CITY OF ALBUQUERQUE

March 27, 2020

RE: 220 Hazeldine SE
Grading & Drainage Plan
Engineer's Stamp Date: 03/26/20
Hydrology File: K14D222

Based upon the information provided in your submittal received 03/26/2020, the Grading & Drainage Plan **is not** approved for Building Permit and Grading Permit. The following comments need to be addressed for approval of the above referenced project:

SW ELEGANT HOMES, LLC.
220 HAZELDINE AVENUE, S.E.
DUPLEX
ALBUQUERQUE, NEW MEXICO
MARCH, 2020

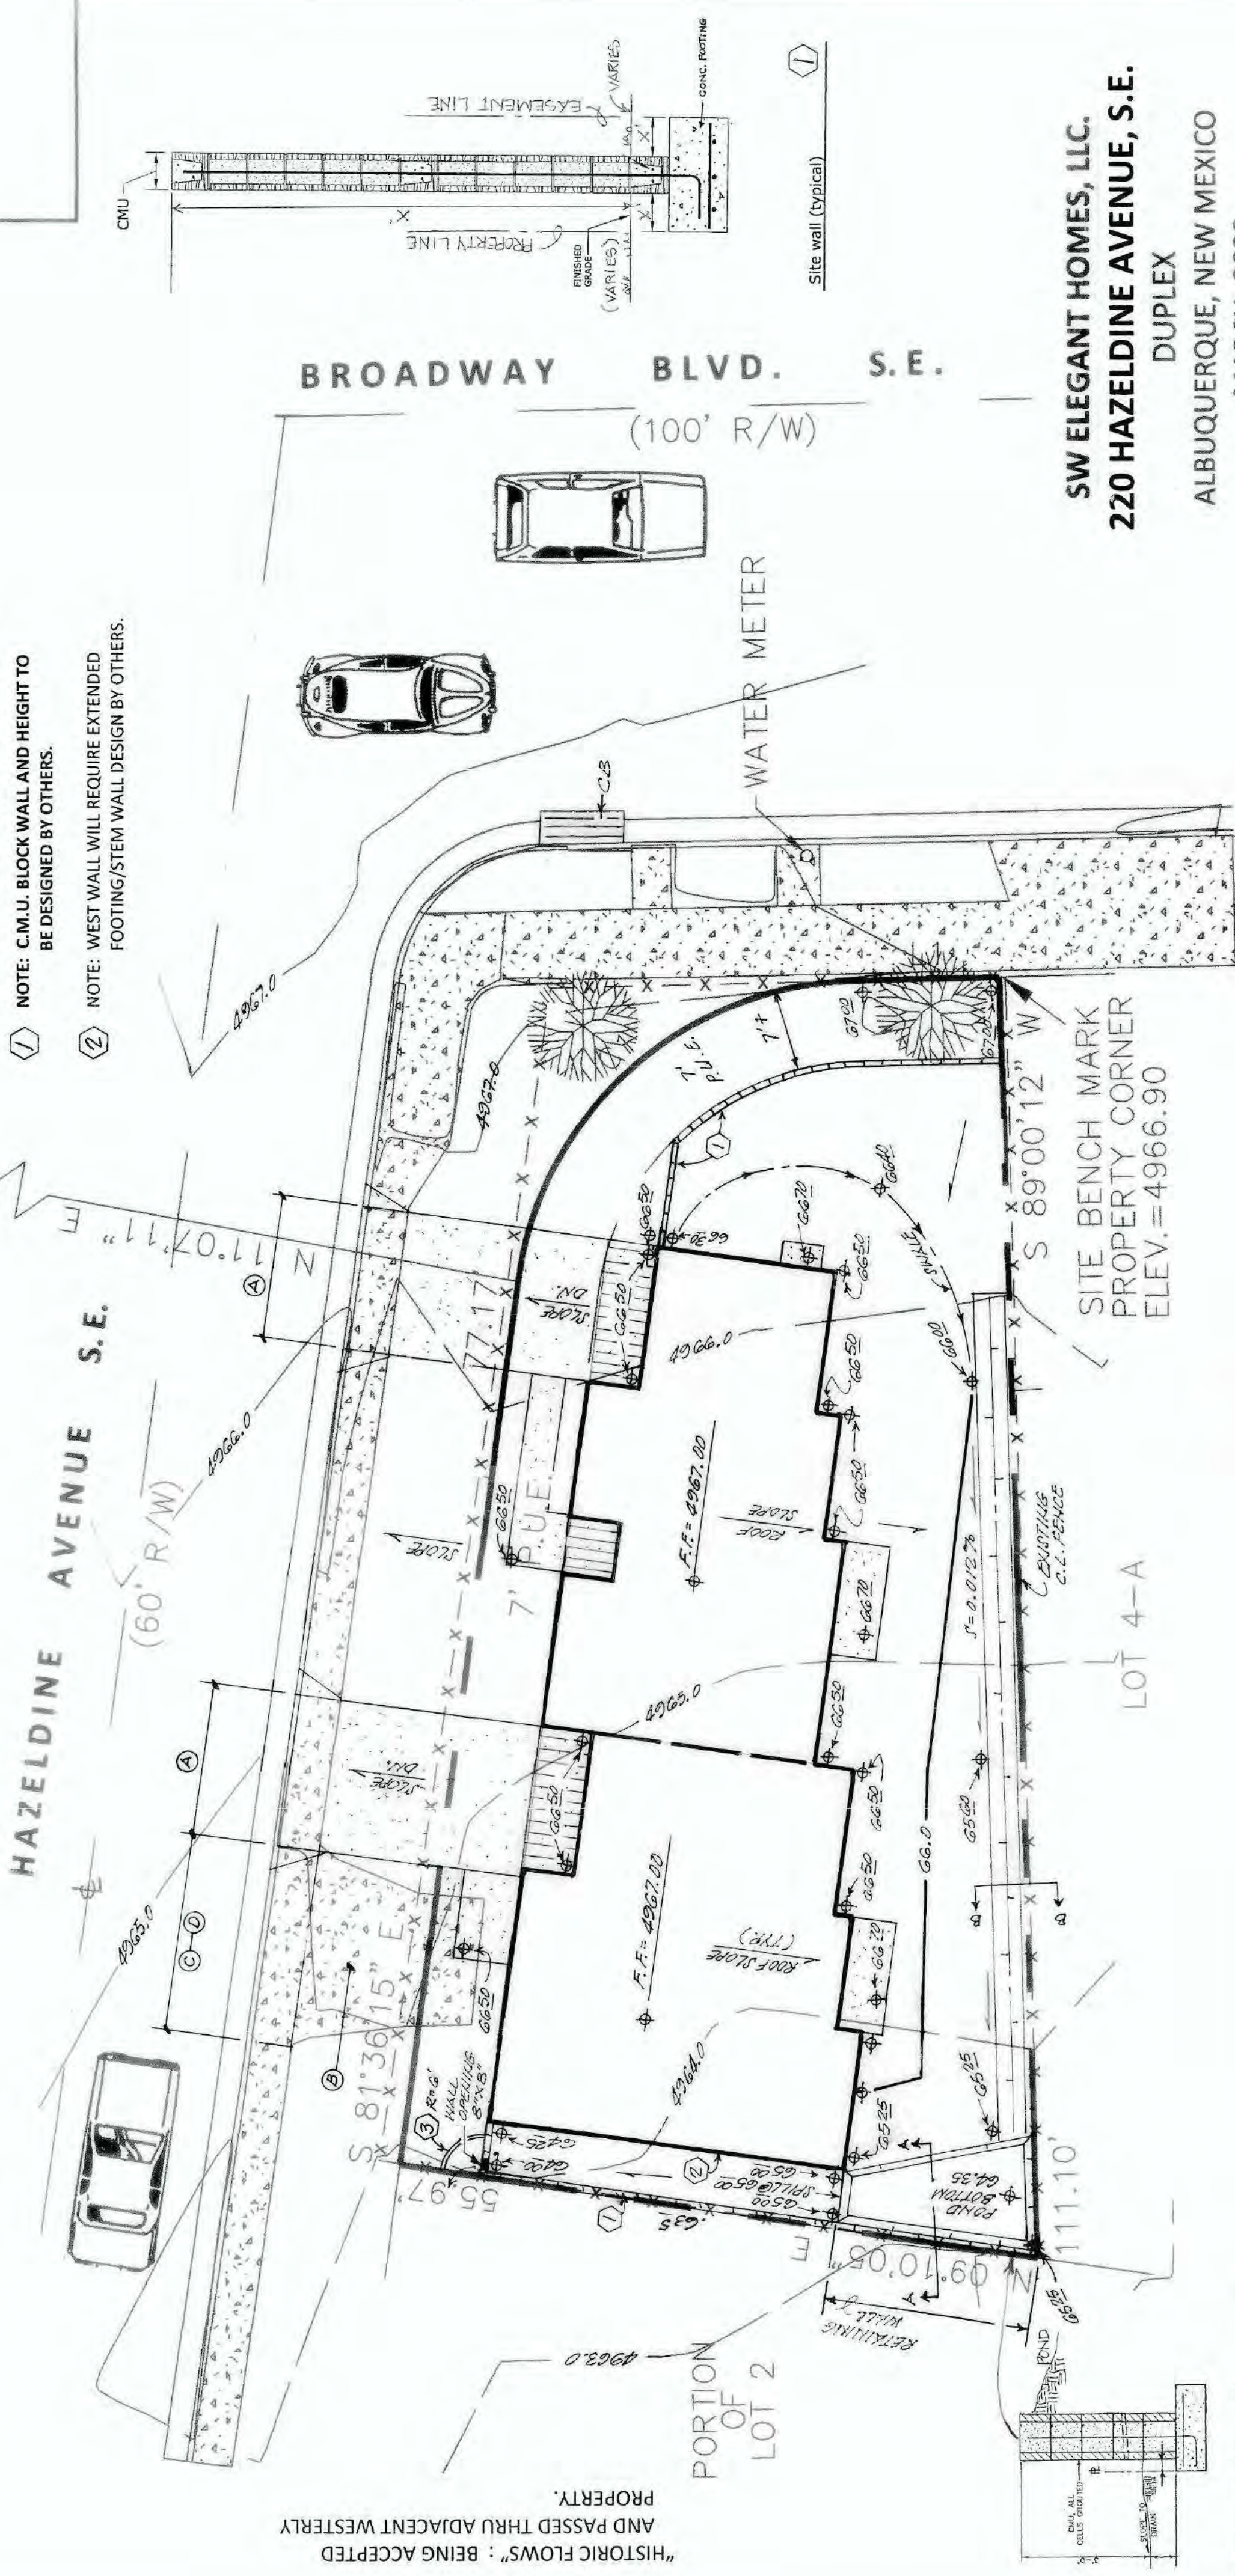
1. Please provide the weir calculations, per DPM Chapter 22.3.A.1, for the 3"x 6" opening in the CMU wall (turn block). A coefficient of 2.7 is typically used for the weir equation $Q = CLH^{2/3}$.

2. Please provide a typical detail for the turned CMU block. This block needs to be at least four (4) inches above the proposed grade to avoid clogging.

3. Provide sections through the proposed retaining walls along the Western property line and along Broadway, showing the footer, distance from the property/ROW lines, existing and proposed grades on either side of the wall. In accordance with DPM Ch.22, section 5 part B, grading and wall construction near the property line may not endanger adjacent property or constrain its use.
